Please find attached the amended drawings in response to the the letter dated 19th January 2015 as well as the reasons for these amendments, described below and according to the mentioned letter:

TITLE: House extension on ground and first floor	
PROJECT: Proposed plans	
CLIENT: Mr Pard Gosal	
PLACE: 67 High Road Ickenham UB10 8LQ	
ARCHITECT ALEXANDRE MIGUEL MARQUES DURÃO RIBA Registration No: 20011737 ARB Registration No: 077740D	
SCALE: 1:100	DATE: November 2014
Drawing Number

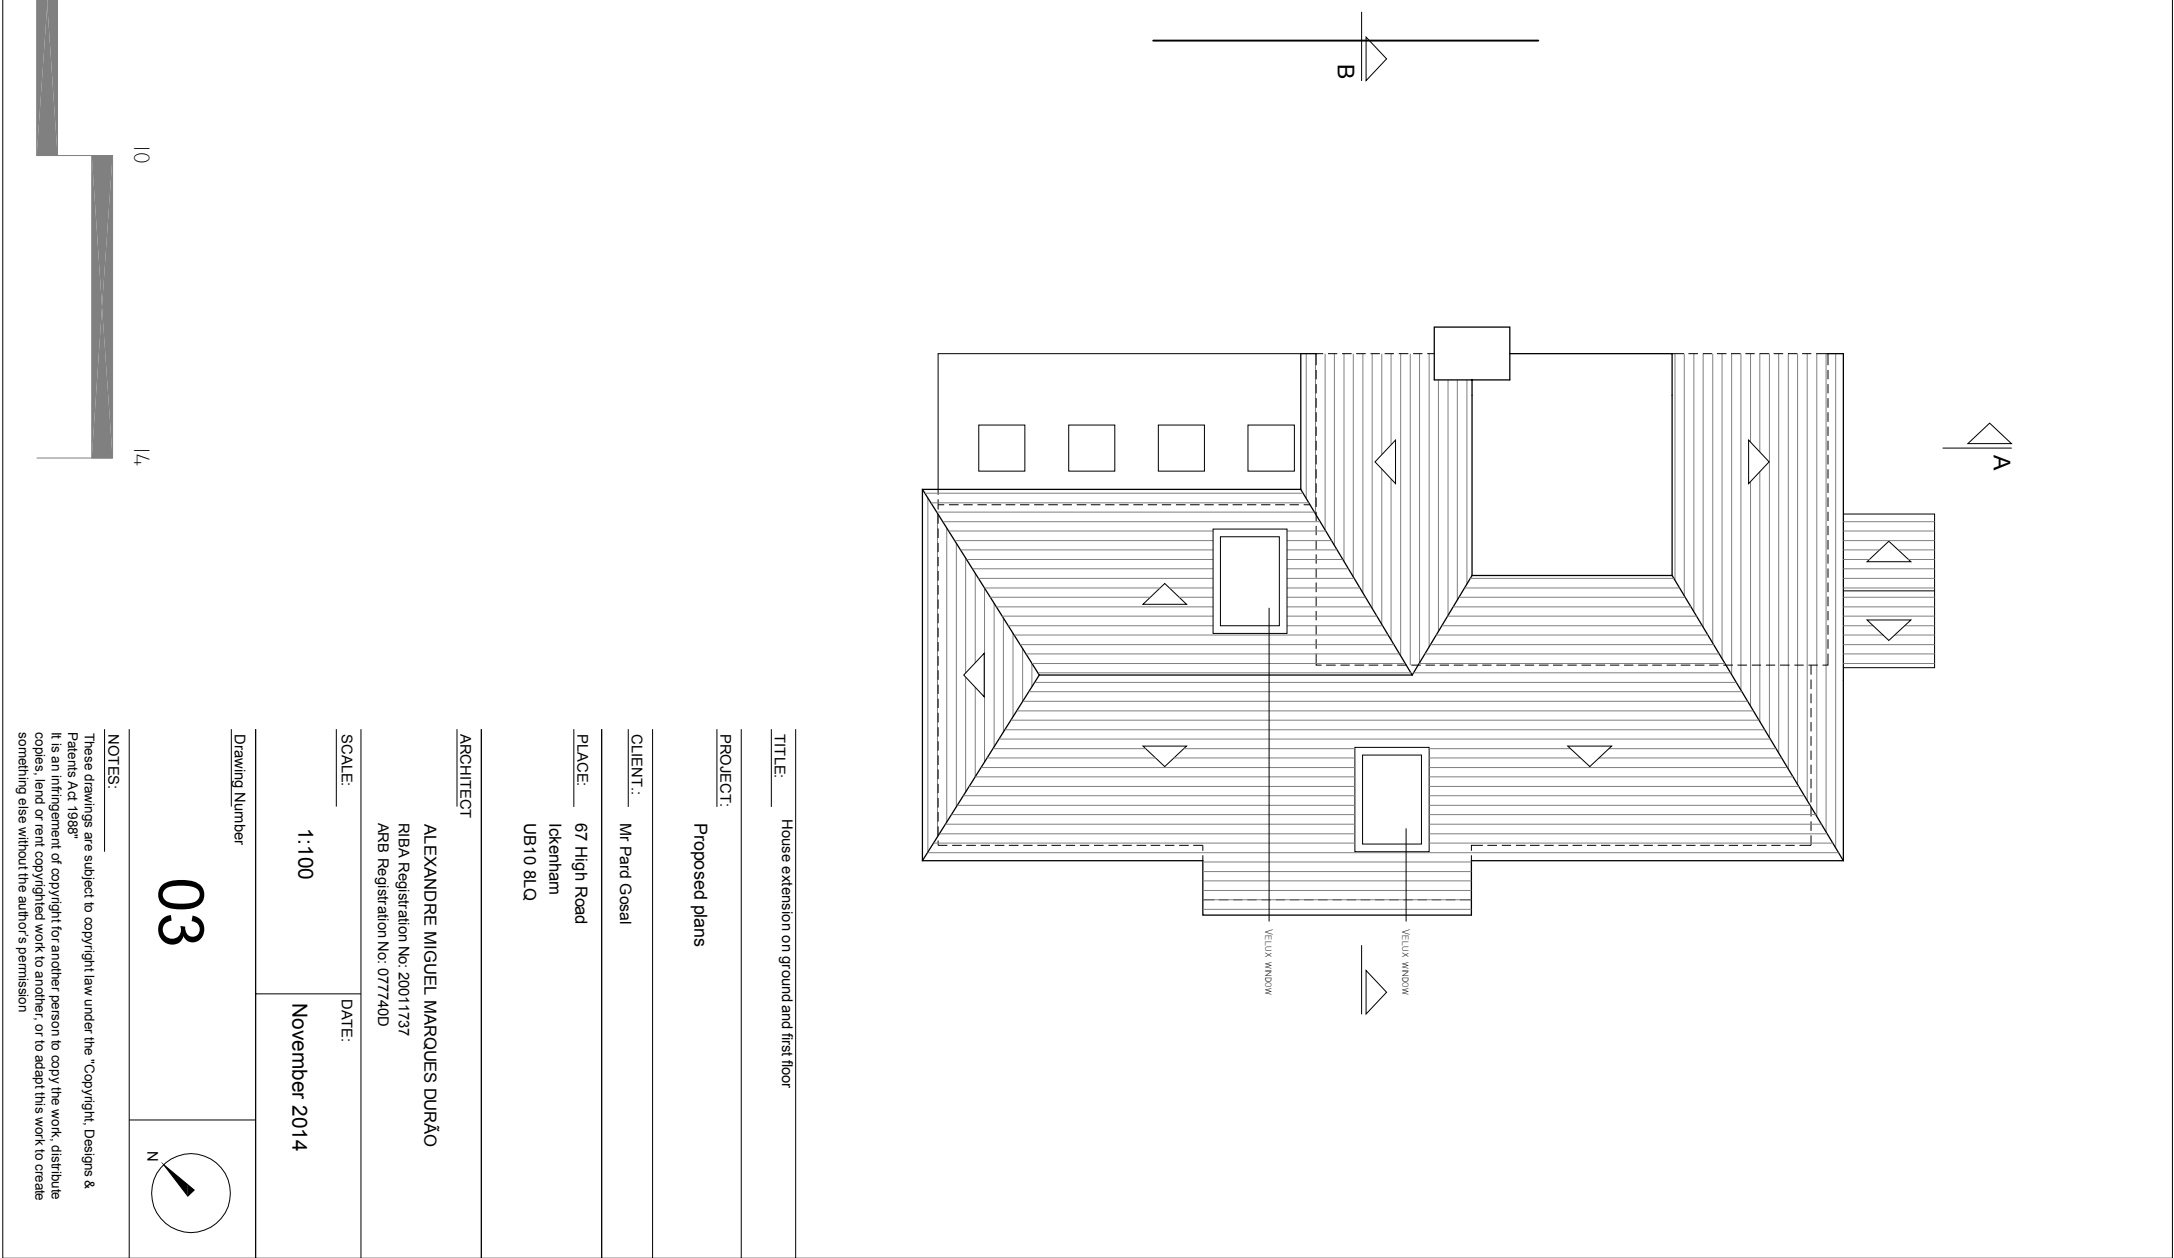
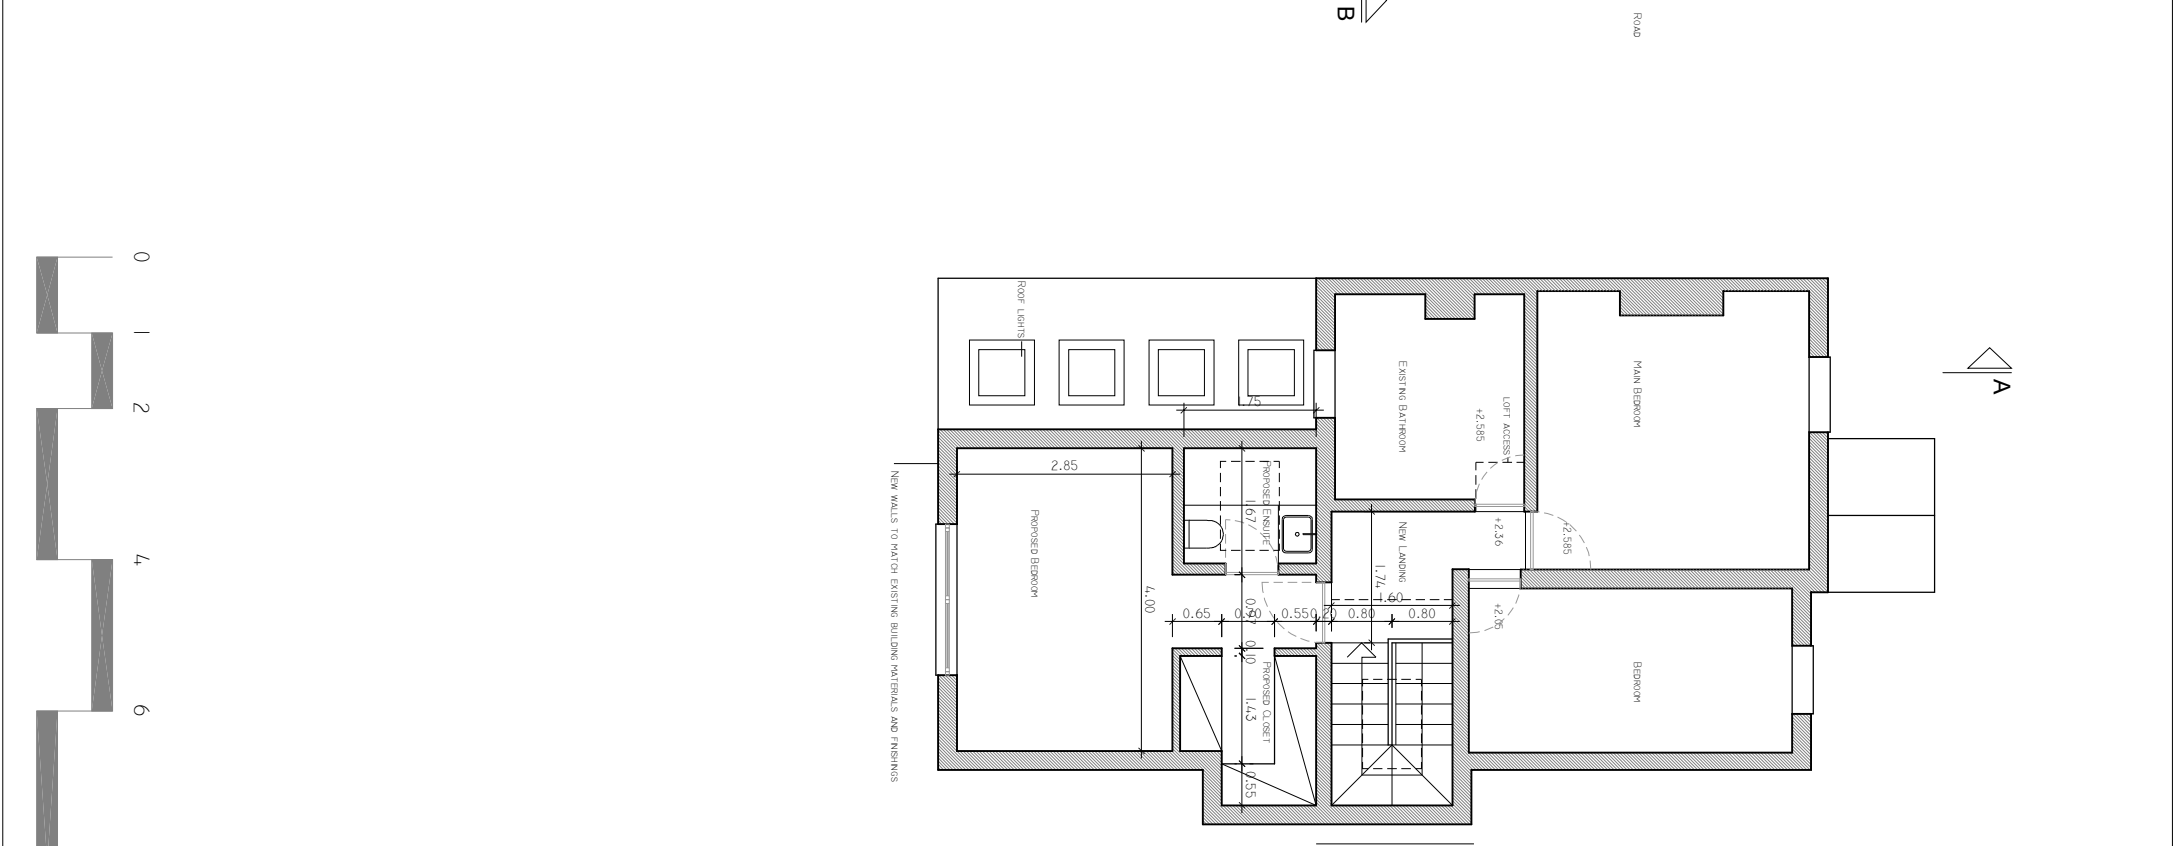
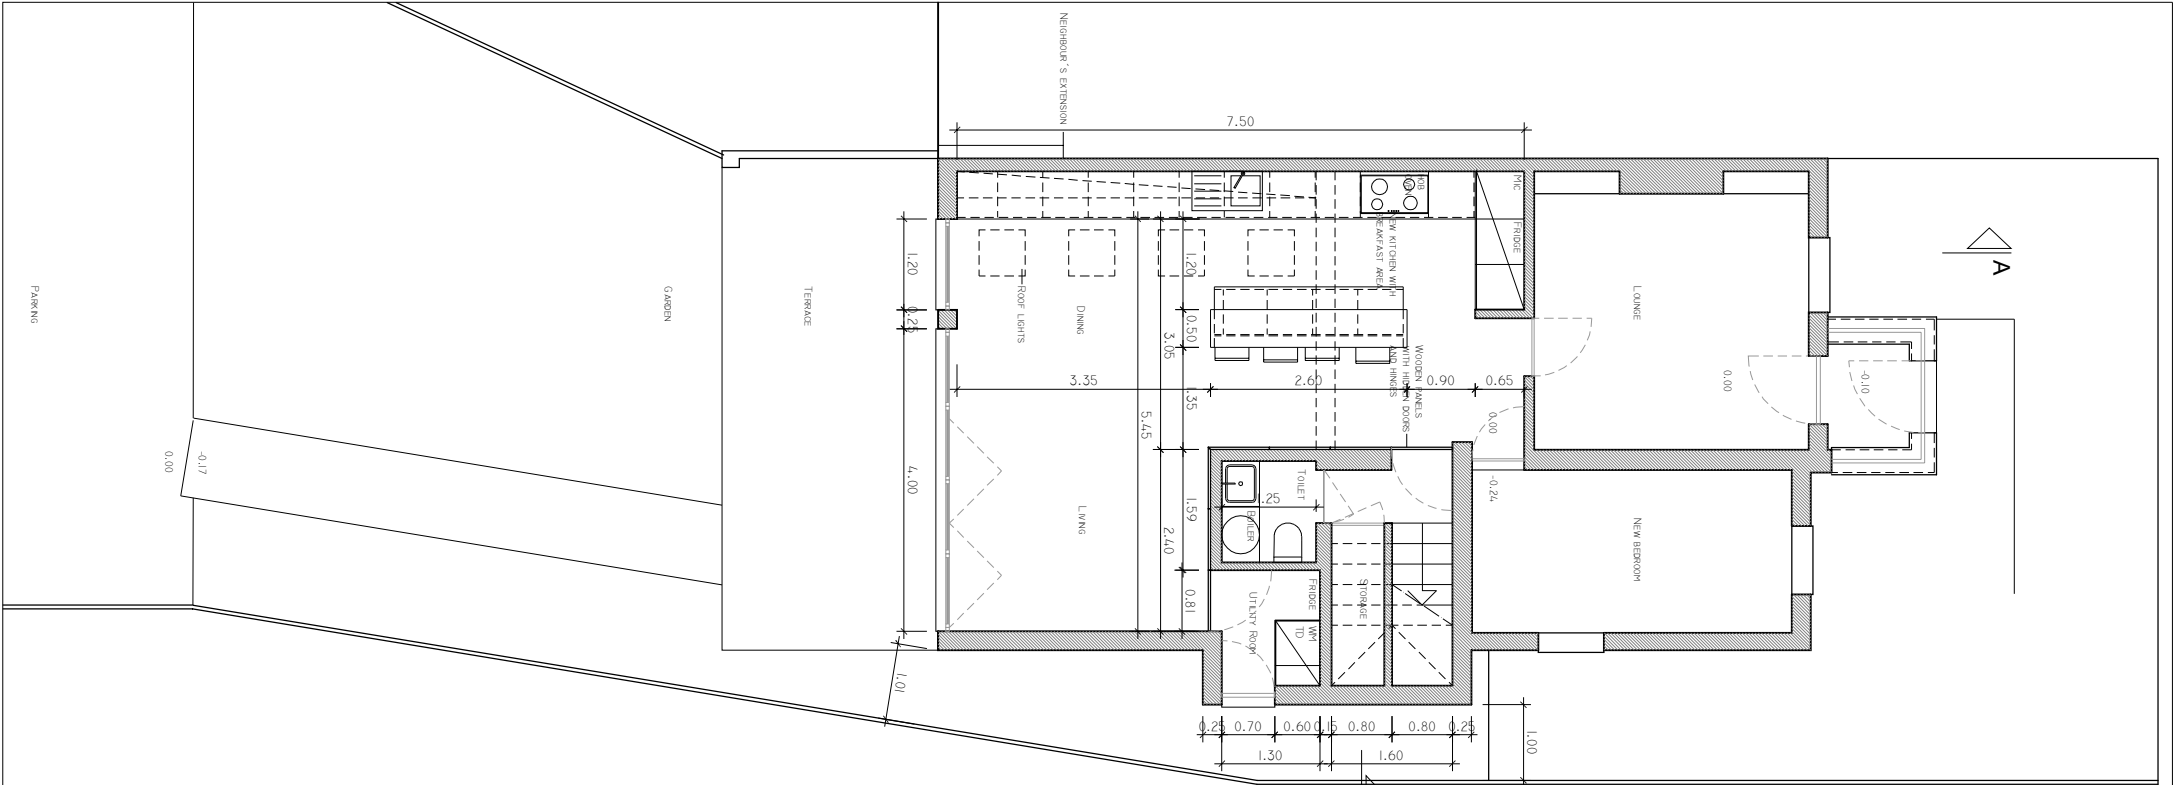
"The proposed two storey rear extension by reason of its size, scale, bulk, excessive depth, height and proximity to the adjoining dwelling at 69 High Road, would be detrimental to the residential amenities of the neighbouring occupiers, by reason of loss of light, loss of outlook, overshadowing and over dominance."

"The proposed first floor side and rear extensions by reason of their size, bulk and design would fail to appear as subordinate additions and would result in the complete over development of the site and have an unacceptable impact to the character of the original property and the visual amenity of the surrounding area"

"The proposed side extension by reason of its size, design, projection beyond the existing side elevation, creation of a crown roof profile and visibility from the public highway would create a discordant and incongruous addition that would unbalance the symmetrical appearance of this pair of semi-detached dwellings"

We changed this extension/ layout. The proposed 1st floor extension is smaller in scale and depth. You can now see the 45 degree line from the neighbouring property and the new extension is set back to the limits of this line. With this solution we believe there is no loss of light, loss of outlook, overshadowing and over dominance (*Any extensions at first floor level should not extend beyond a 45-degree line of sight taken from the nearest first floor habitable room window of the neighbouring property."*)

We changed the drawings accordingly. We are not extending to the side elevation any more and the extension at the back is appear as a subordinate addition to the existing building. We believe there is no over-dominance

There is no side extension any more so there are no visible changes on the main elevation
